Engineers Comments Regarding Surface Water Drainage

APPLICATION NO: BR/57/20/DOC

Site Address: 15-17 Kew Gardens Bognor Regis PO21 5RD

Description of Works: Approval of details reserved by condition imposed under ref BR/63/19/PL relating to Condition Nos 8 - surface water drainage and 9 - maintenance and management of the surface water drainage.

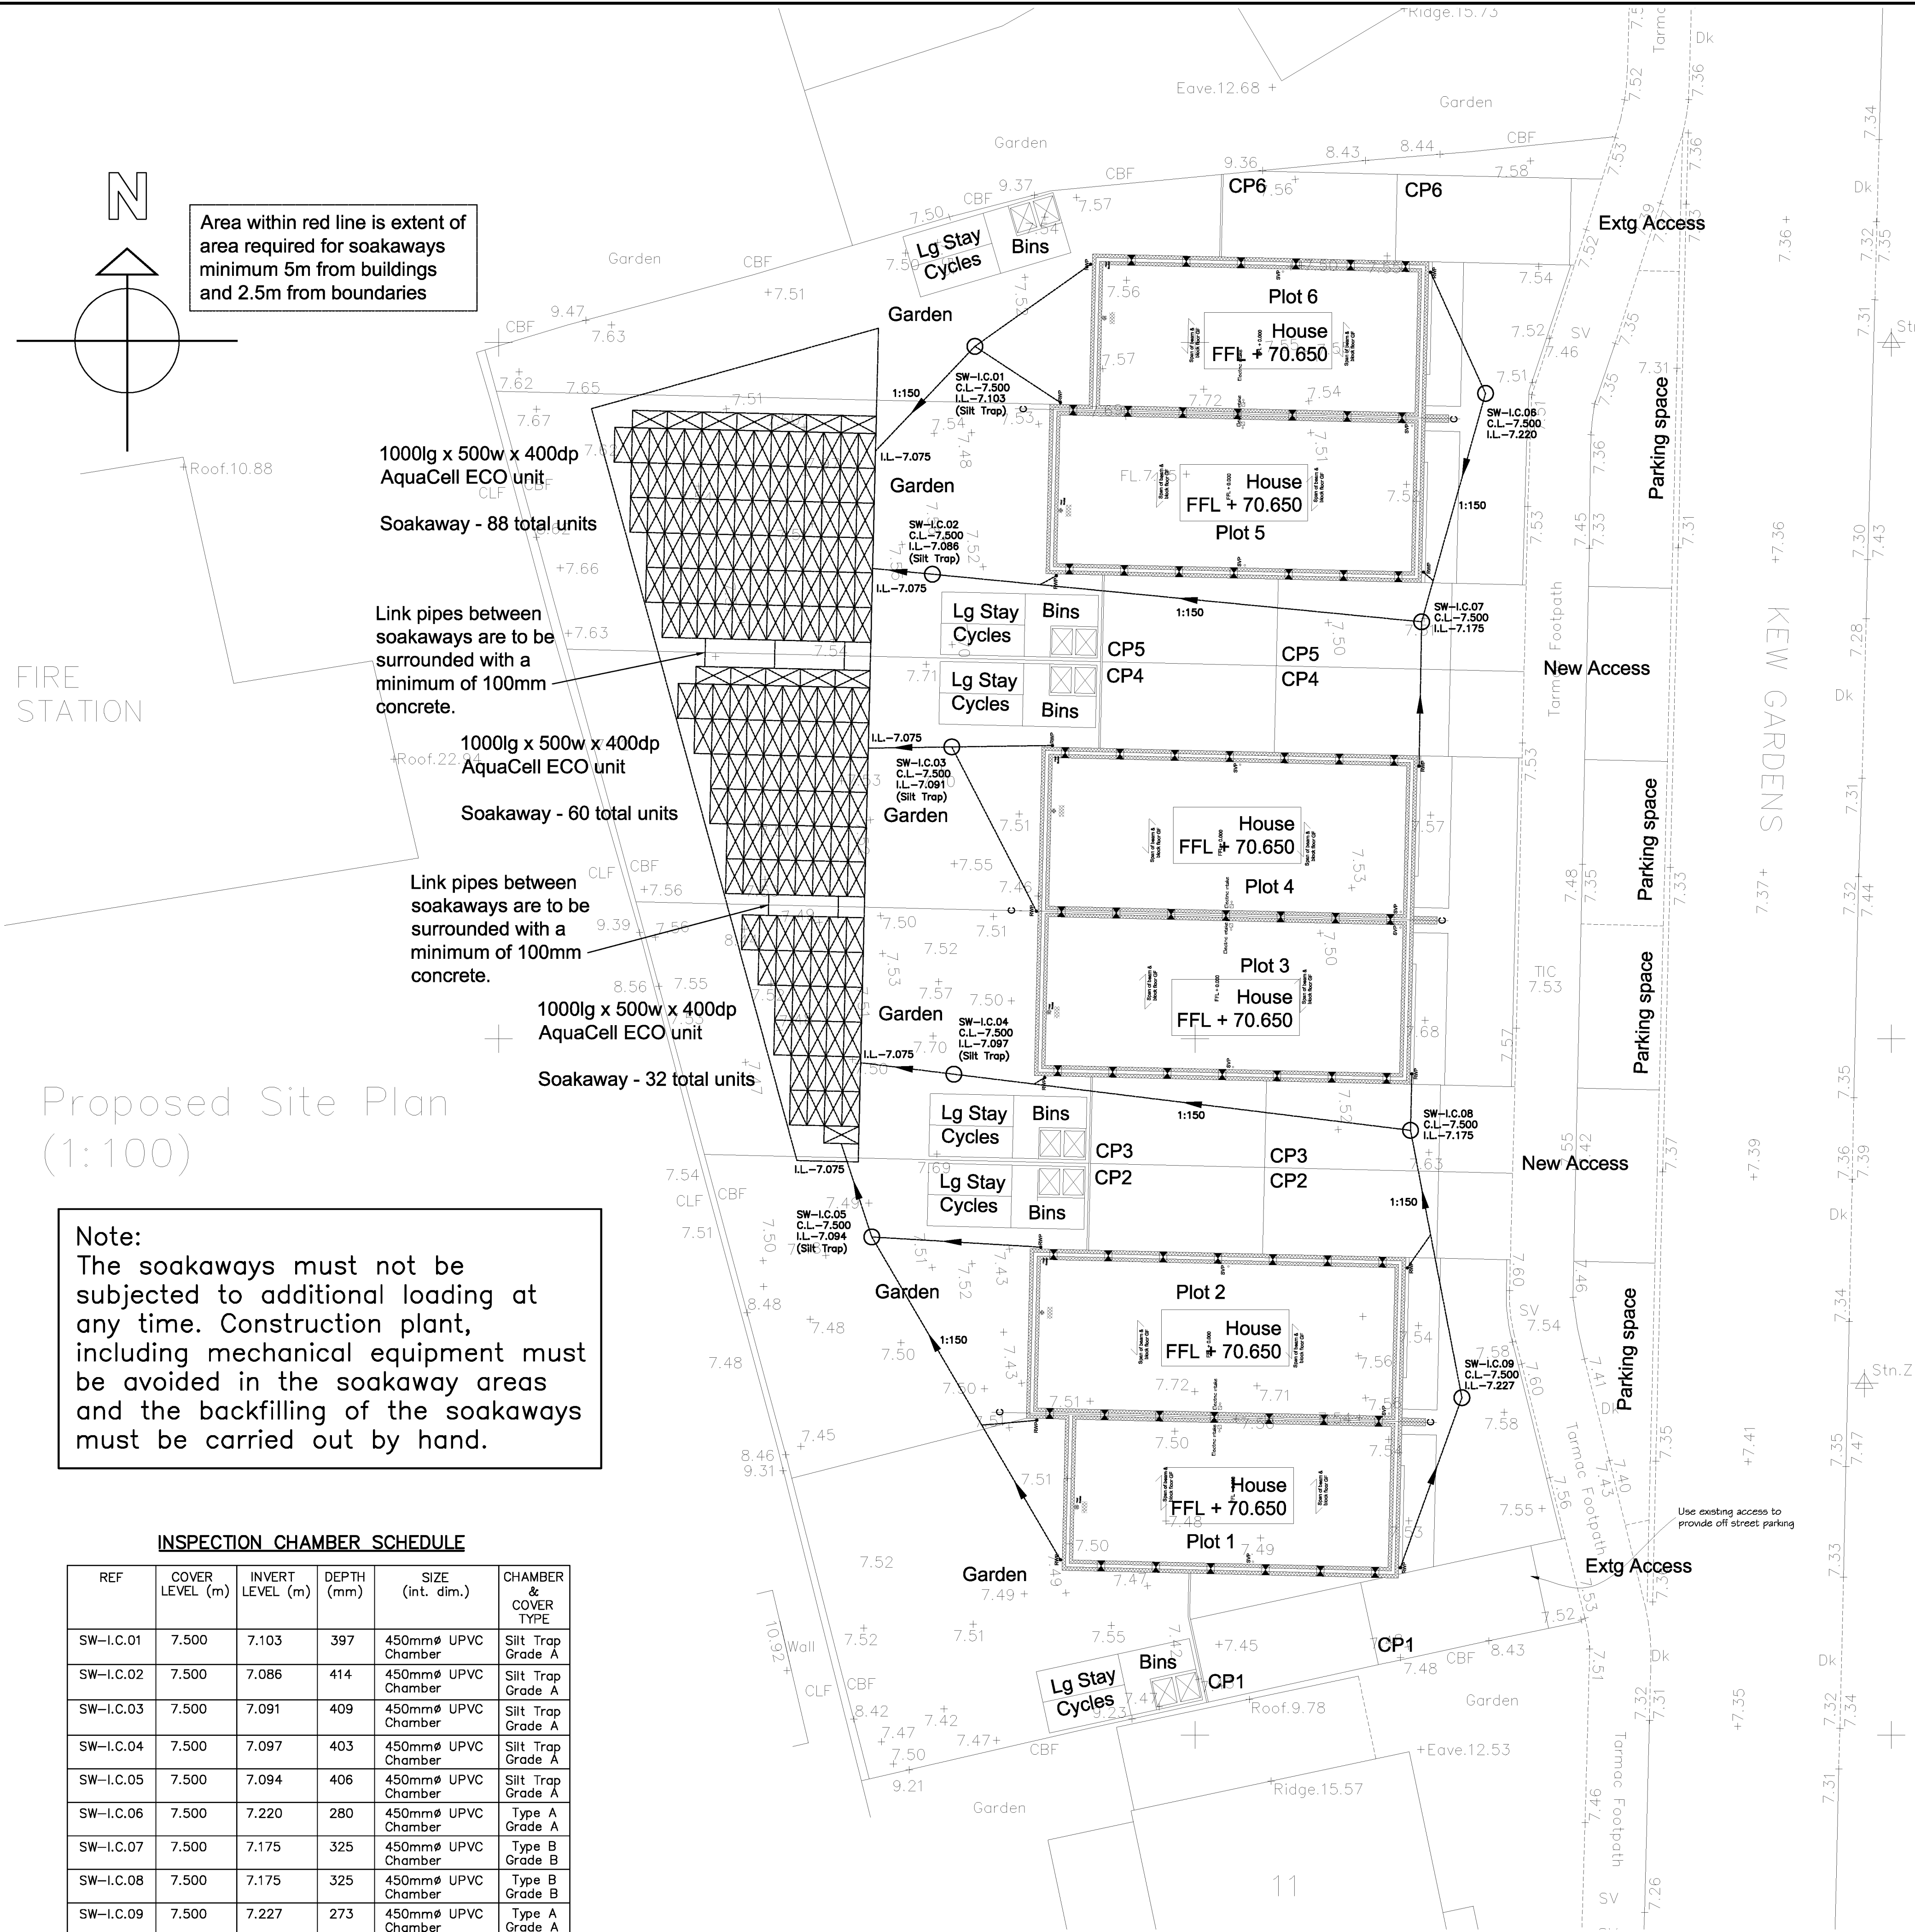
1. Soakaway crates are shown going beneath the boundary fences at plot 2/3 and plot 5/6. The design needs to be modified so that no crates are under boundary fences. Done.

2. The link pipes between the soakaways need to be surrounded in concrete and it is strongly advised that the applicant includes an inspection chamber on at least one of these pipes (please label this manhole/inspection chamber with invert and cover levels and cover type). Concrete surround specified, no inspection chamber.

3. Please label all pipes with the diameters, pipe materials, surround type, falls and/or invert levels. (If the diameters and materials are consistent a note to that effect stating the specification is sufficient). Done.

5. All silt traps need to be labelled with their invert levels. Done
6. Provide construction detail drawings for the silt traps, inspection chamber, permeable paving and the two different pipe bed and surrounds. Done.
7. Please provide a prominent and clear note that the soakaways must not be subjected to additional loading at any time. Trafficking by construction plant on site, including mechanical equipment, must be avoided. This includes when backfilling the soakaways themselves. Done

In relation to point 2. My engineer says that there is no requirement or need to have inspection chambers on the link pipes. The link pipes are very short lengths and are encased in concrete therefore provide a sealed link between soakaways. The link pipes are short in length therefore putting a manhole on them will mean putting it on the fence line which is not practical. The manhole would then be push further to one side of the fence very close to the soakaway. This is just not practical or needed.

TYPICAL SECTION
STORM WATER SOAKAWAY DETAIL
1:20

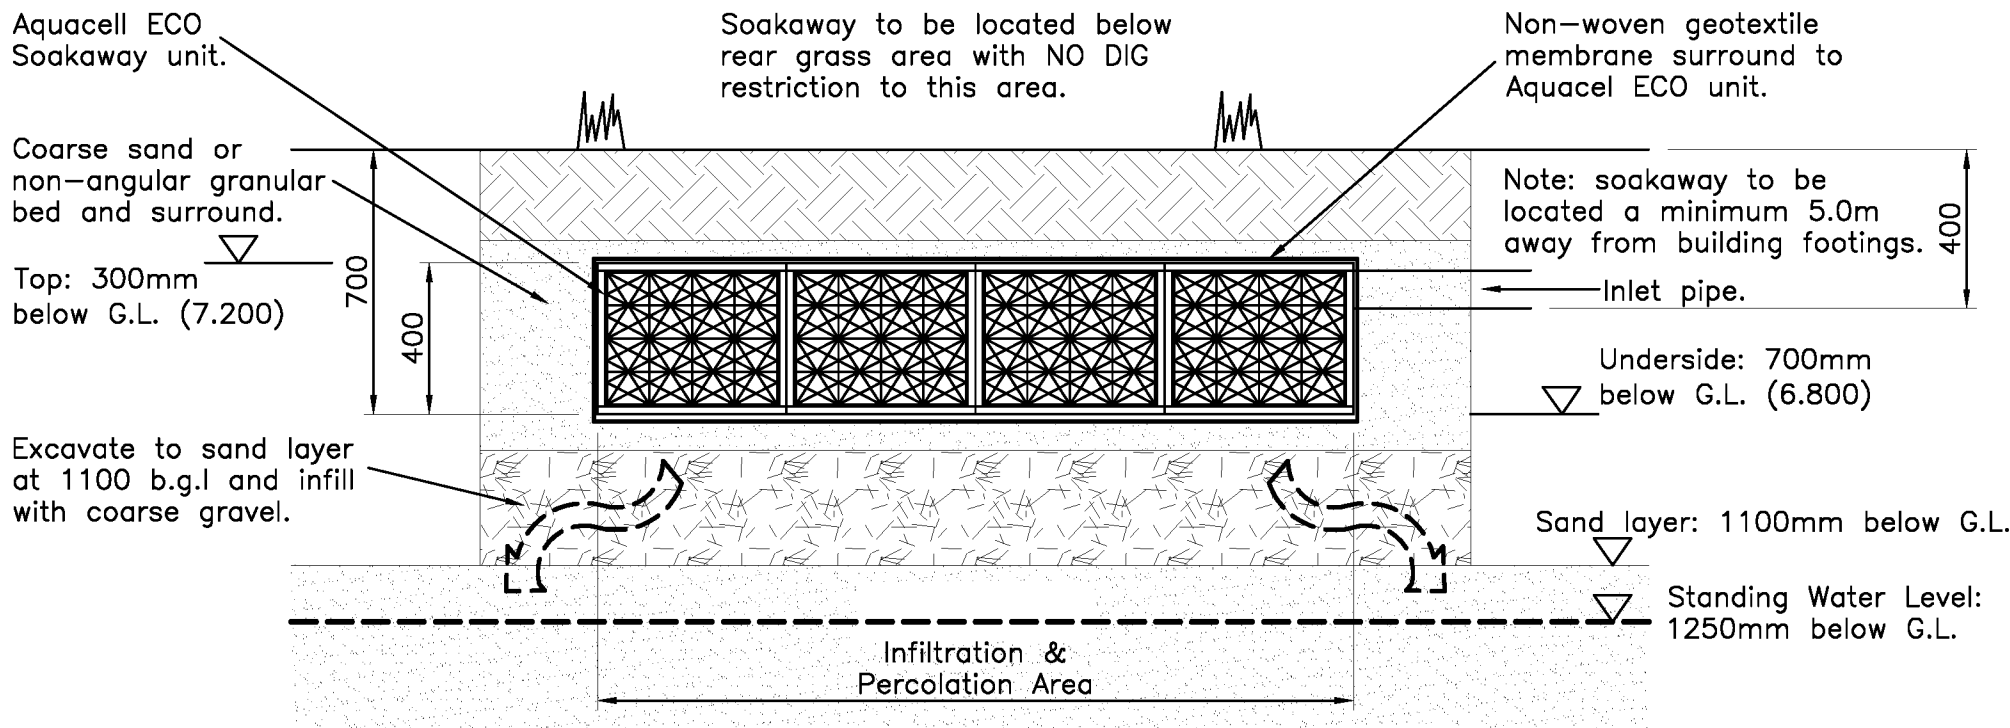
4. Please label soakaways with their invert levels, cover levels and cover types (not necessary if construction detail is kept on same drawing, in which case "see detail for levels" – only if moved to a separate construction details sheet, see below). This is still unclear, the existing topography shows ground level to be

at 7.5 for most of the soakaway areas which will only provide 300mm of cover rather than the 400mm specified. Luckily this is acceptable with the chosen crates, however the note needs to be changed to reflect this. In addition, the levels on the site vary and yet the cover depth is uniform on the detail. It is assumed that the three soakaways will be set at the same base level 6.8. If this is the case, using the detail is sufficient, however the cover depth should be changed to reflect that it varies for the different soakaways. I.E. Min 300mm and Min 700mm to the base of the soakaway.

In relation to point 4. We have provided the details of the soakaways as standard details. Generally the existing/proposed ground levels to the rear gardens is uniform at around 7.5m Yes it is accepted that the ground might vary 100mm across the site but the detail shows the worst case scenario of having a minimum cover of 300mm and the soakaways being all set at the same base level of 6.8m. I don't see why we have to specifically change the detail to show exact ground levels the detail is standard and the contractor will work with this and then adapt ground levels and covers to suit. It seems you are expecting the details to be spot on with levels but in reality there will be fluctuations of around 100mm on site. The detail provides the required information for the soakaways to be constructed to regulations and this will be adapted to ground conditions/levels on site which will be inspected by the building inspector and warranty provided.
